EN020027 – Norwich to Tilbury 400 kV Reinforcement

Deadline 8 Submission by Rex Webster: Interested Party [REDACTED]

Impact of the Proposed Development on Farming at Flordon Hall, Flordon, Norfolk

Representation – Vision/Intrusion

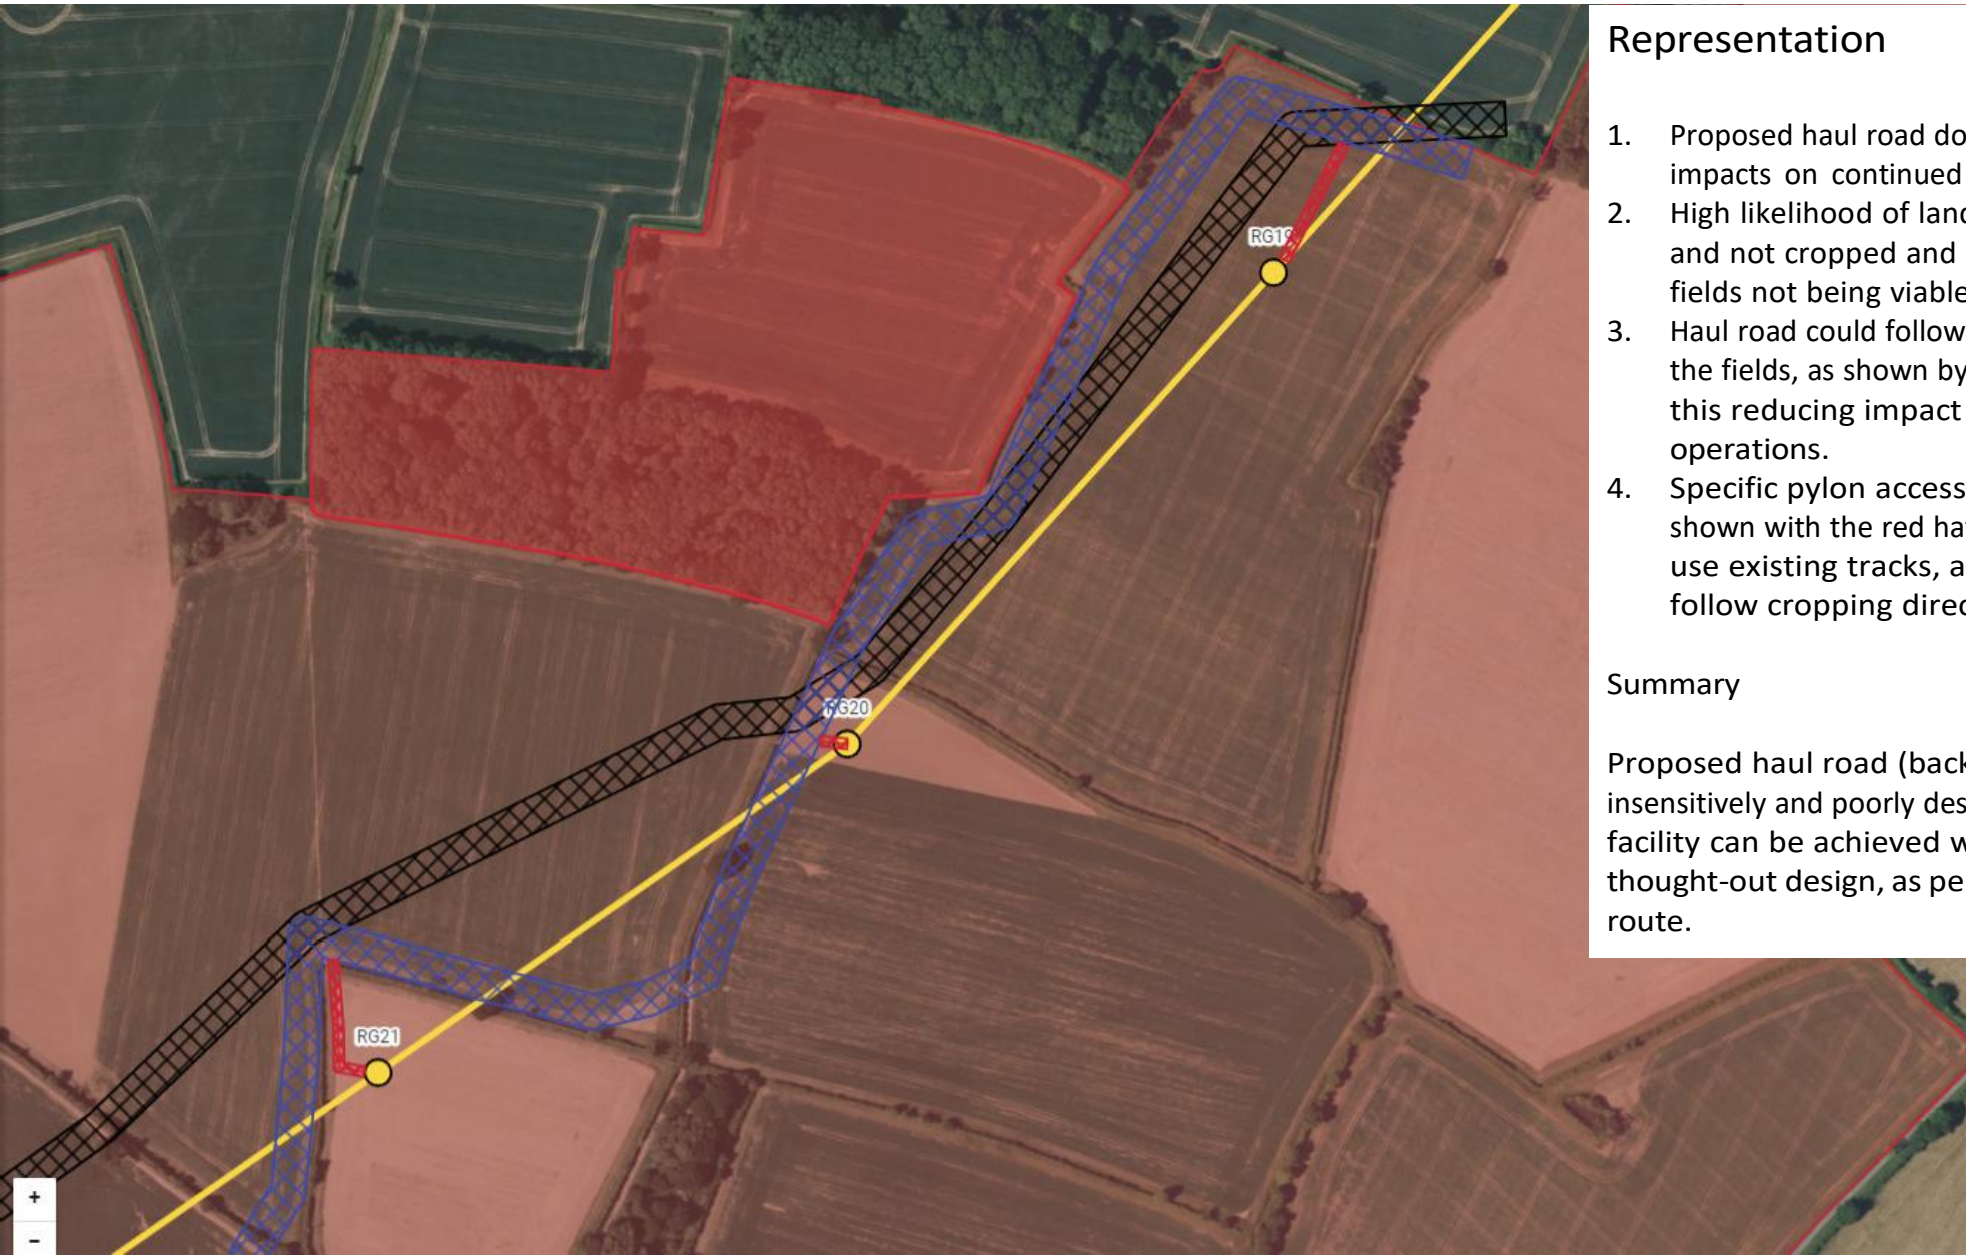
The proposed location of pylons RG21 and RG22 would introduce two approximately 50-metre-high industrial structures into the immediate setting of these heritage assets.

During consultation I suggested an alternative alignment which remained entirely within my ownership but would have reduced these impacts substantially. The Applicant has not provided a convincing explanation as to why this alternative was rejected.

Representation

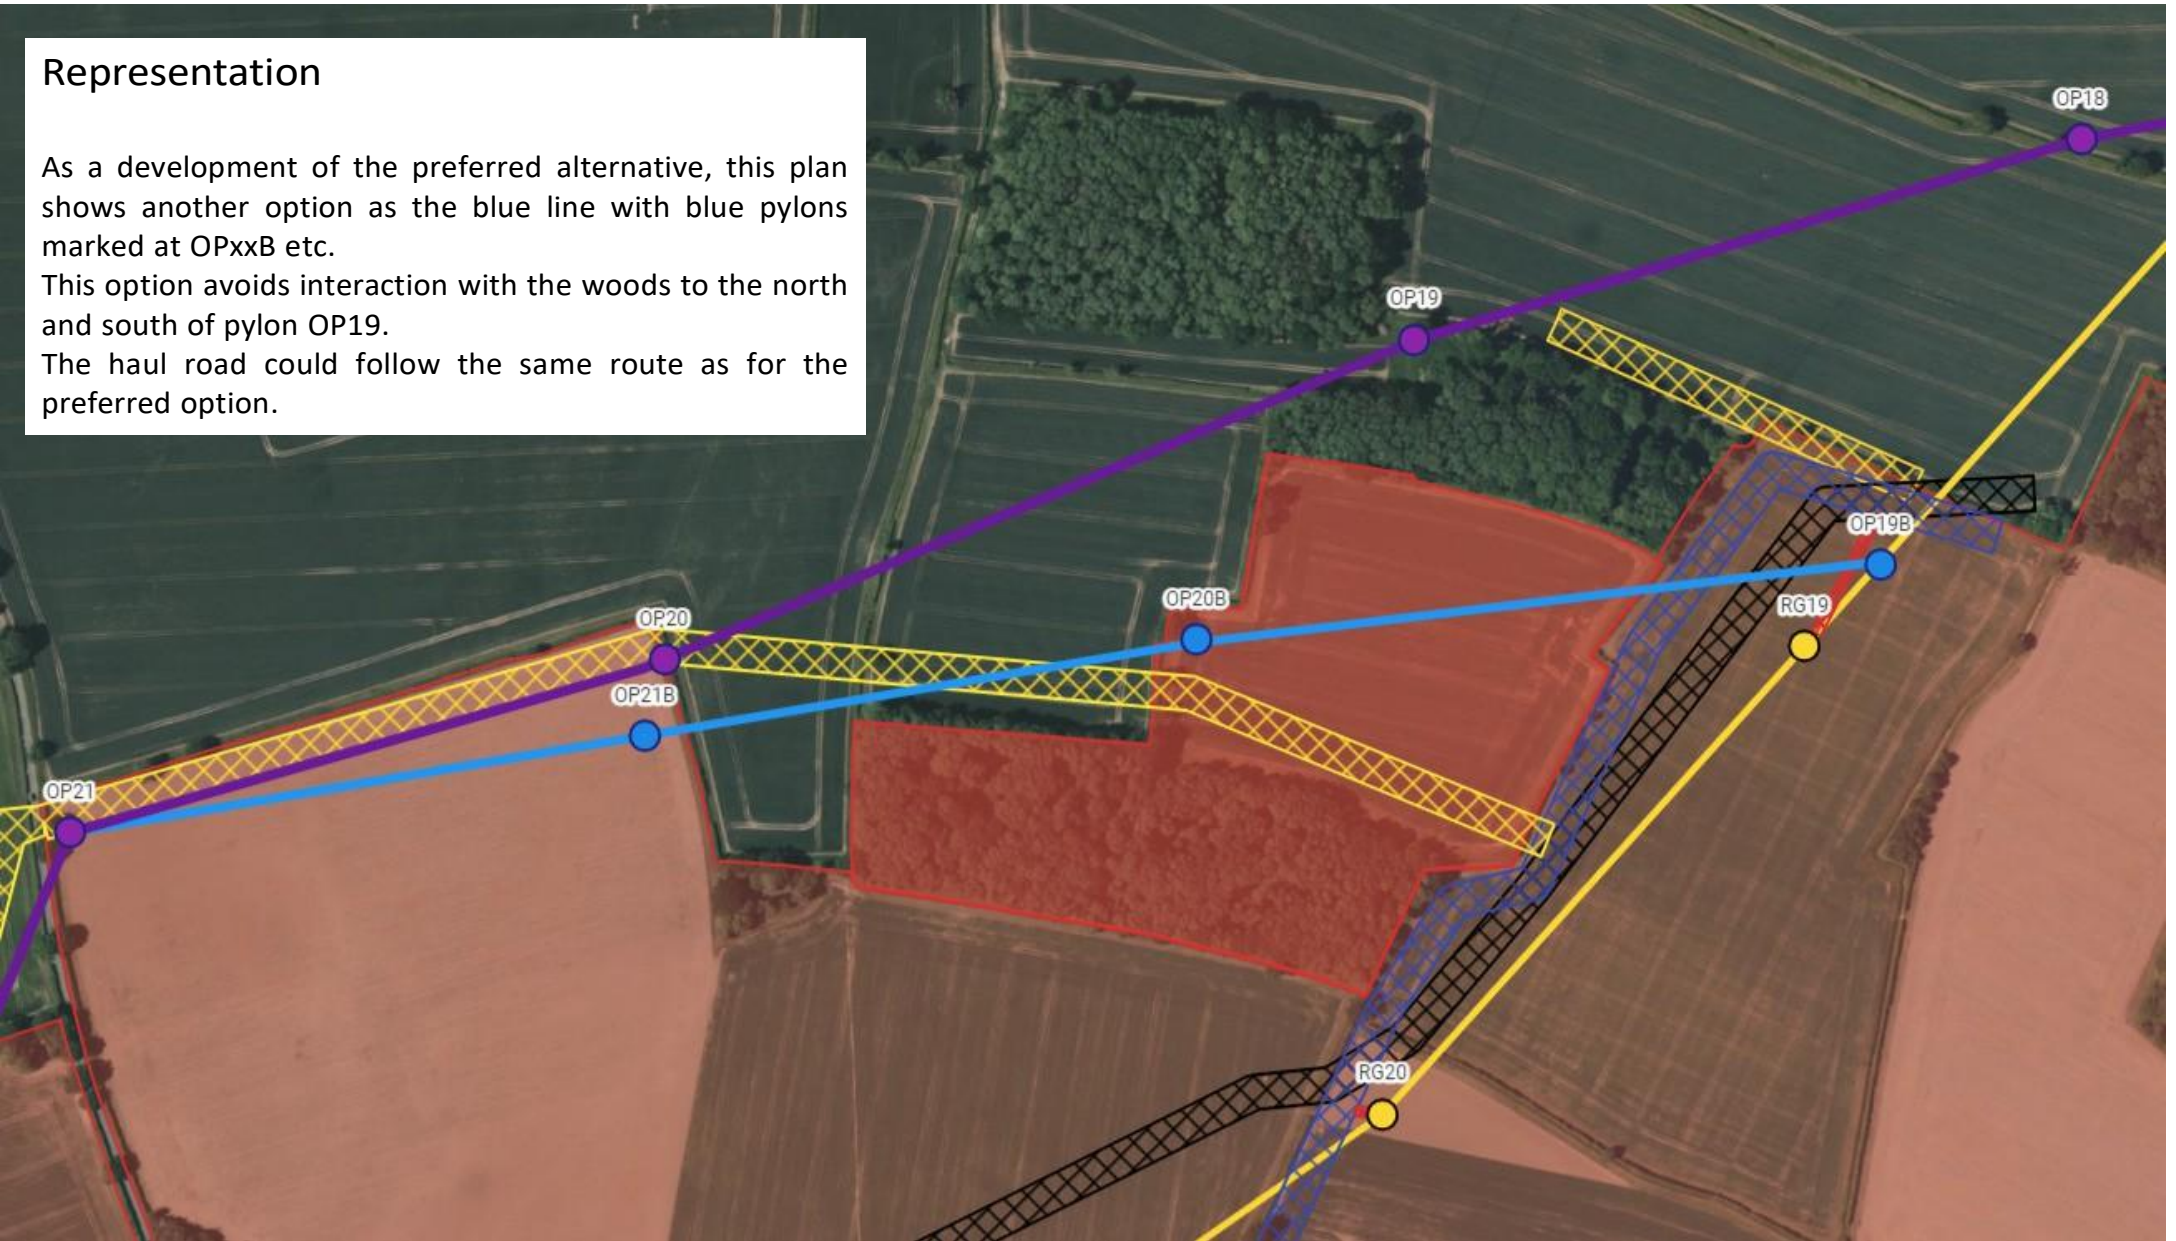
The alternative alignment proposed by me would have remained within the same land ownership while reducing impacts upon farming operations, ecology, residential amenity and heritage assets.
